READ PARISH COUNCIL

Planning Application No: 3/2013/0271

Proposal: Proposed erection of two detached dwellings – re-submission

Location: Land at George Lane Read

Client JWPC		
Job Title Proposed development to Land at George Street Read		
Drawing Title Proposed Site Plan		
Scale 1:200@A1	Date August 2013	Drawn J Bowden

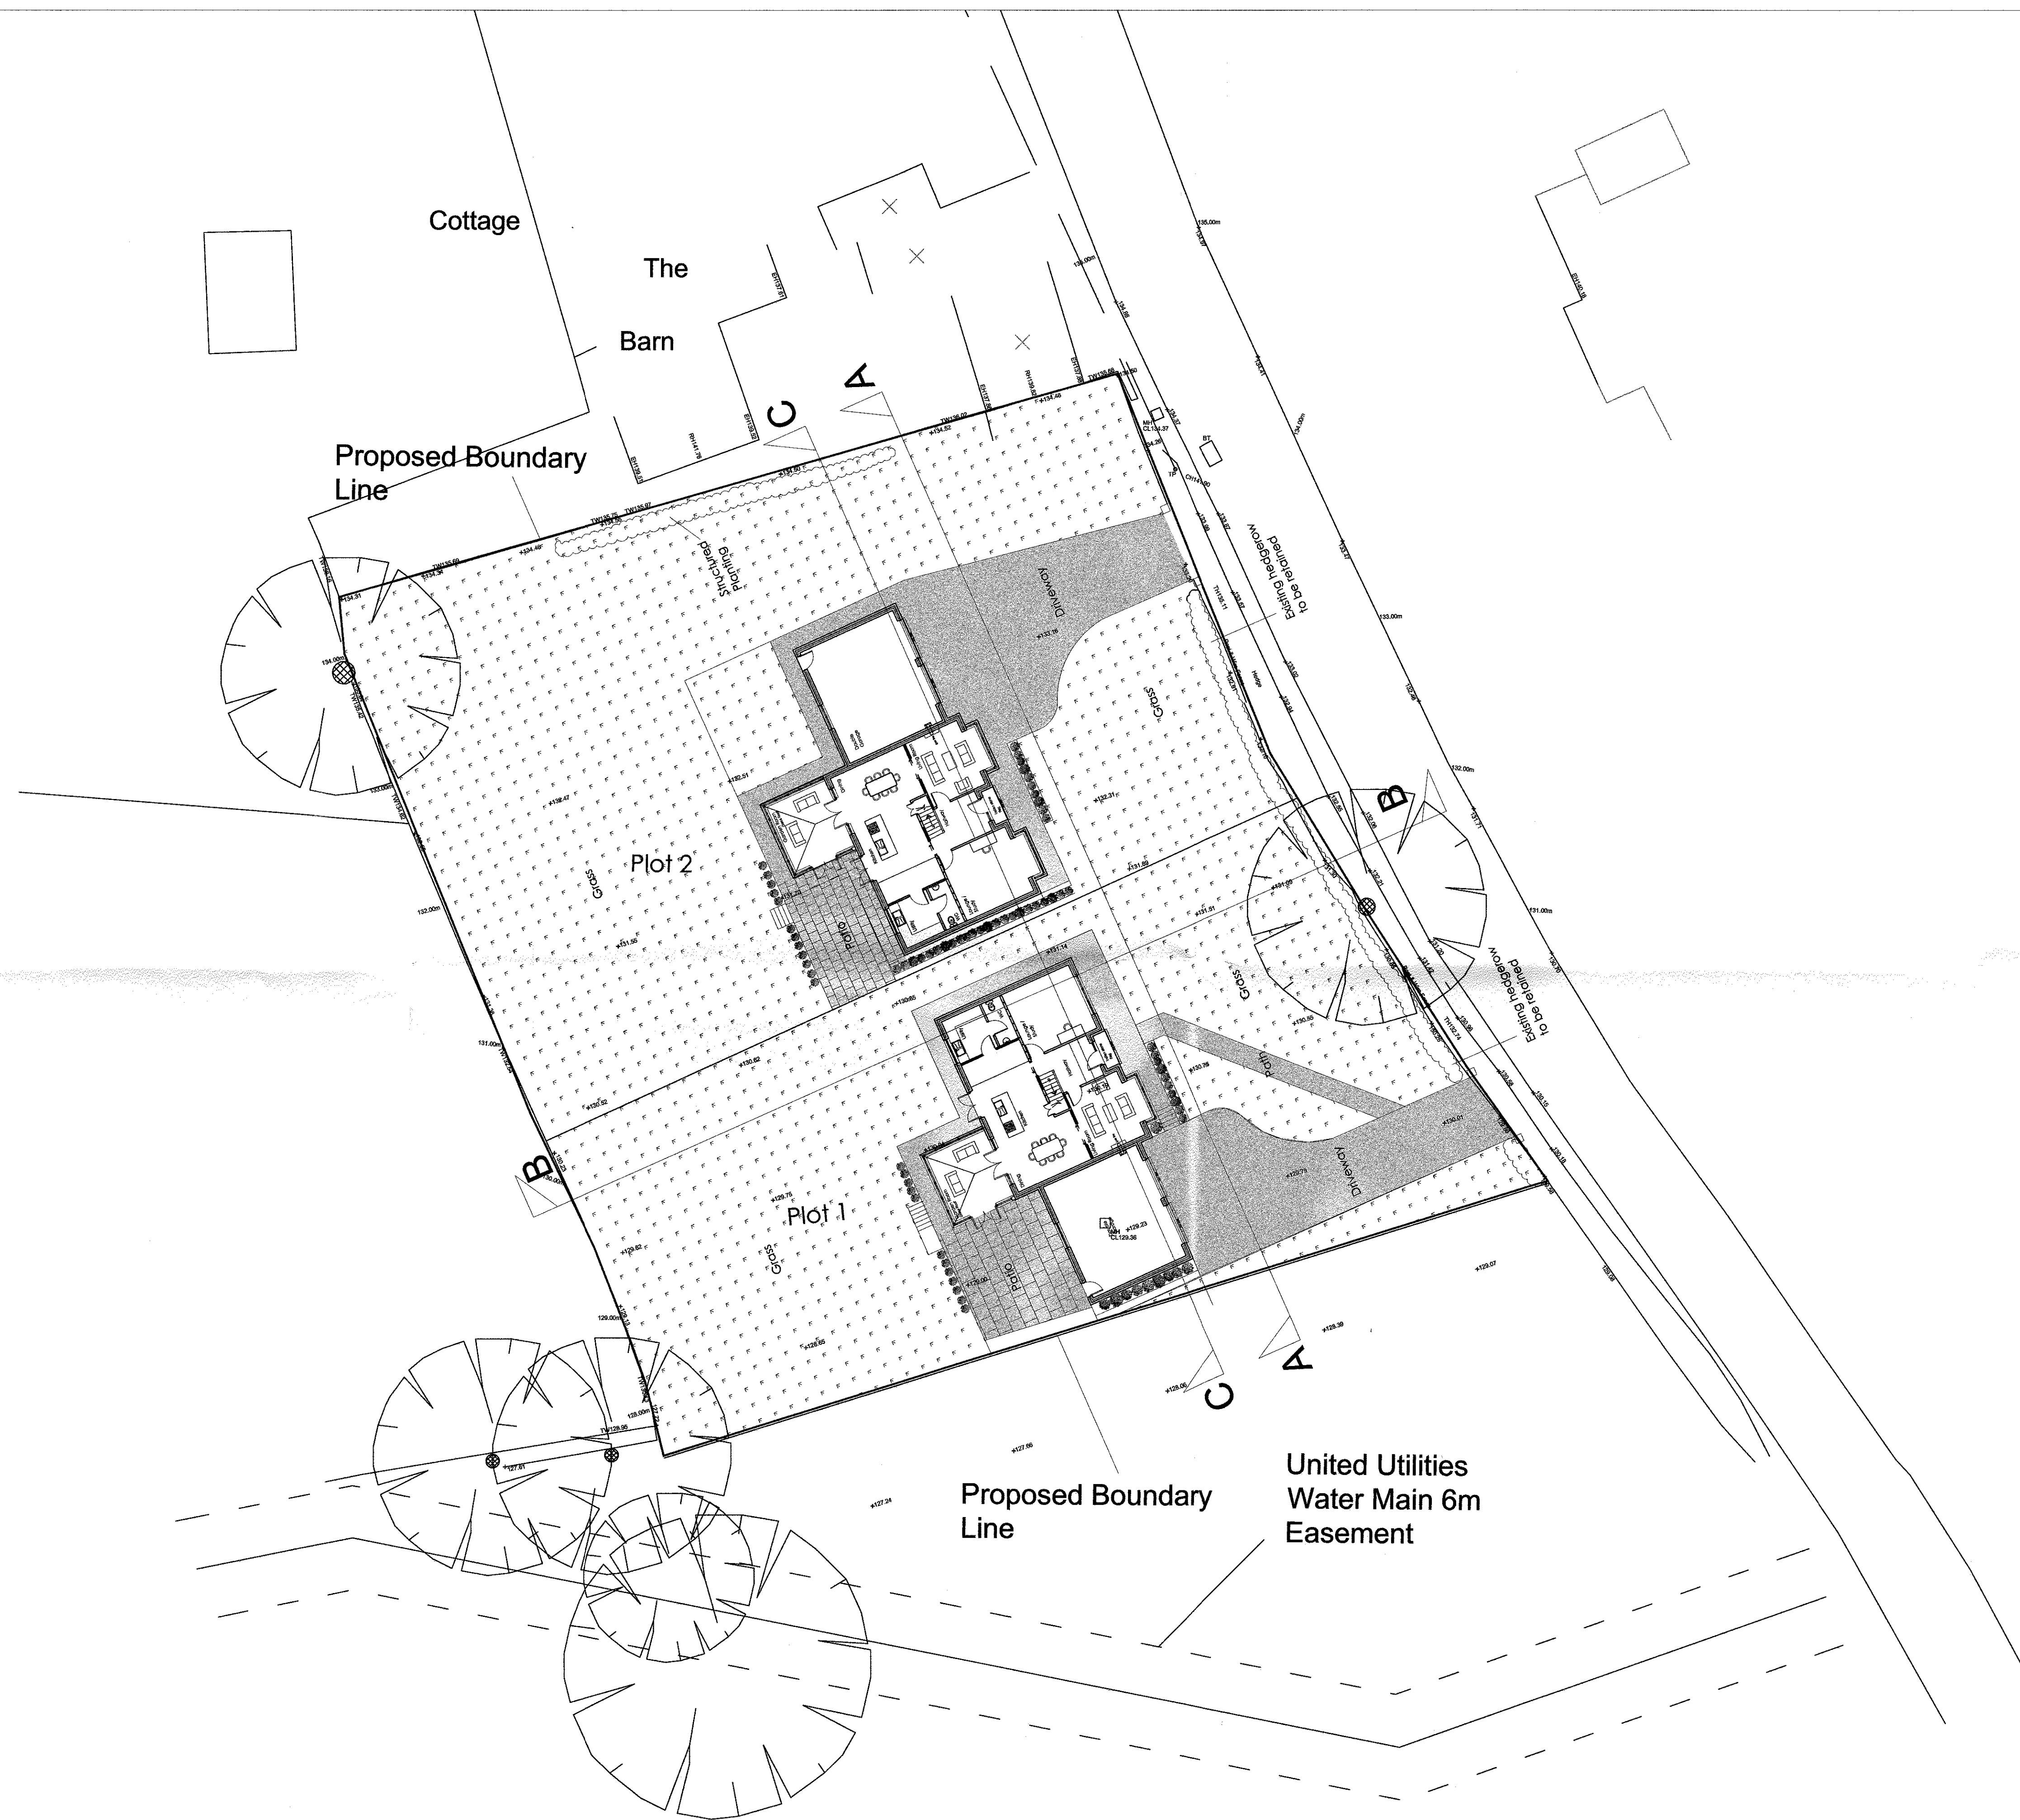
The Parish Council are satisfied that the modified plans address previous issues satisfactorily but would ask that consideration be given to the access to Hammond Field for the farmer.
